Application No: AW/359/20/PL

Site Address: Co-op Supermarket 2 Nyetimber Lane Aldwick PO21 3HG

Description of works: Introduction of one way system & marked parking bays to the existing parking area, new armco barrier to protect shopfront, new mechanical plant at rear of store with key-klamp protection & alterations to existing timber store which include new secure metal door & new felt roof to replace existing polycarbonate roof covering. This site is in CIL Zone 4 (Zero Rated) as other development.

Thank you for your internet representation made on 2nd February 2021 which has been recorded as no objection with the comments as follows:

PROPOSED SITE PLAN 1:200

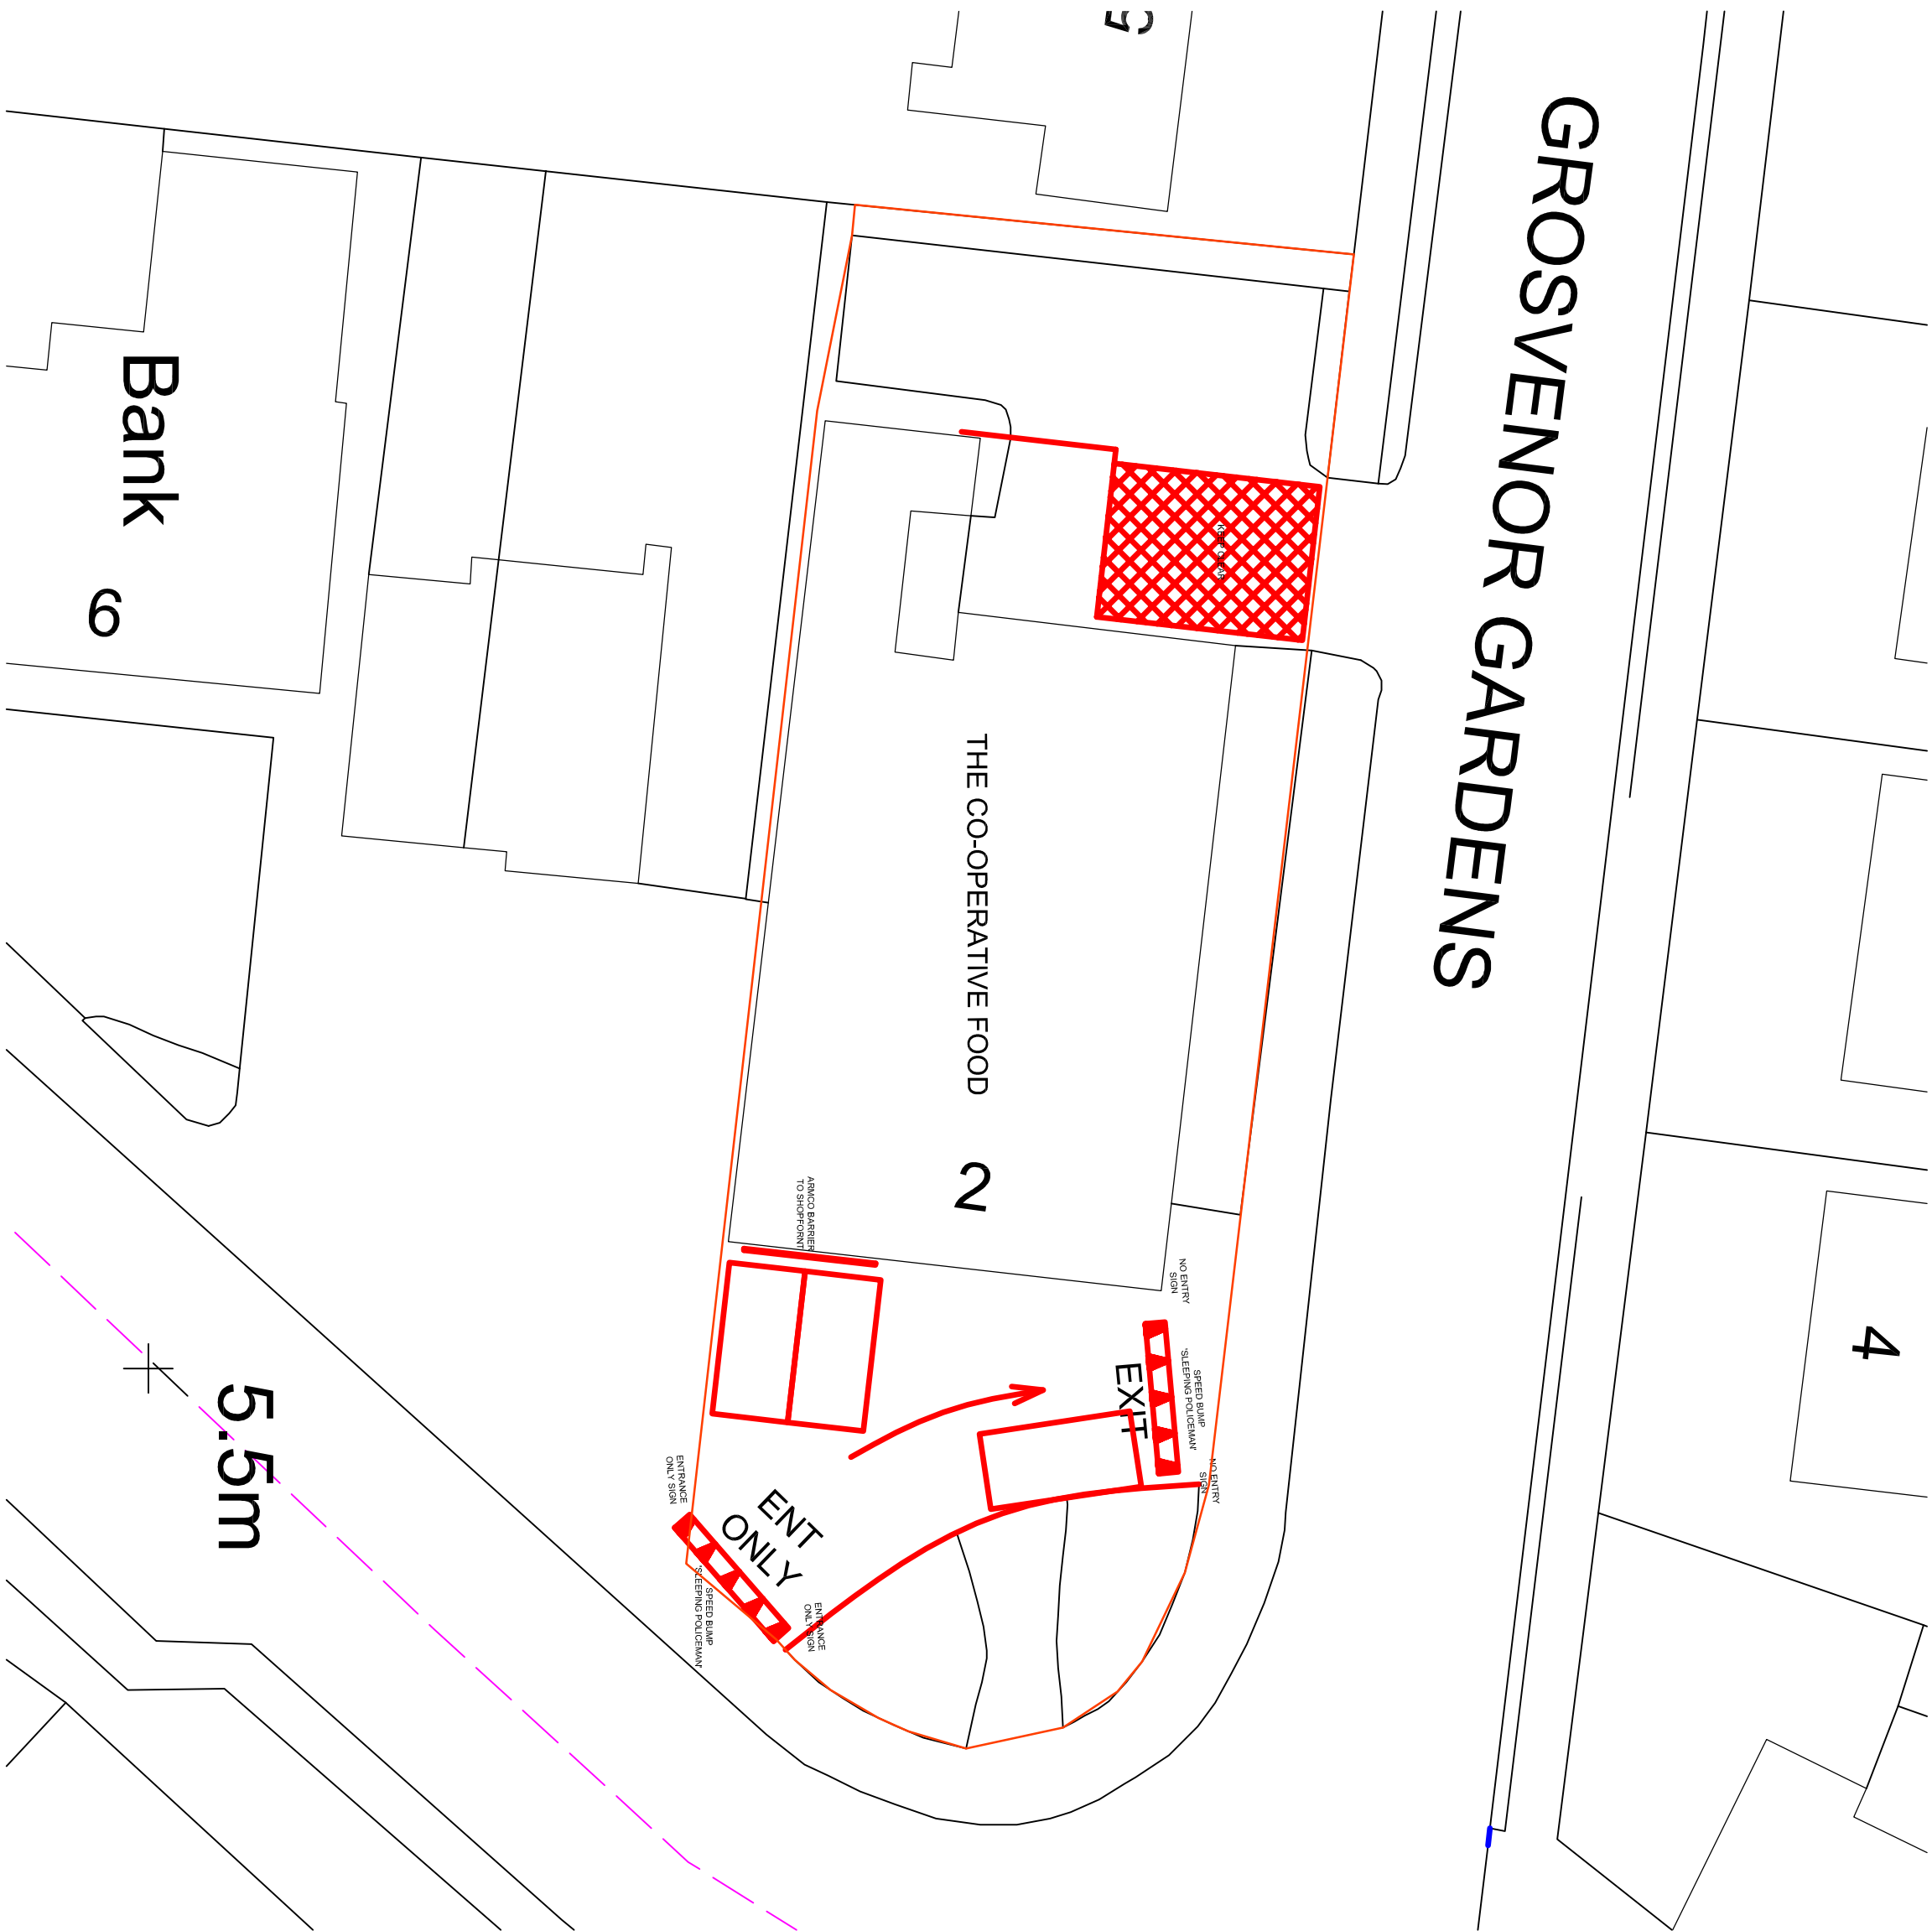
Members had no objection to the application though they expressed the hope that a pedestrian route to the shop should be clearly delineated and that a space for queueing, when necessary, outside the shop be allowed for and that yellow lines should mark off the pedestrian areas from the parking areas.
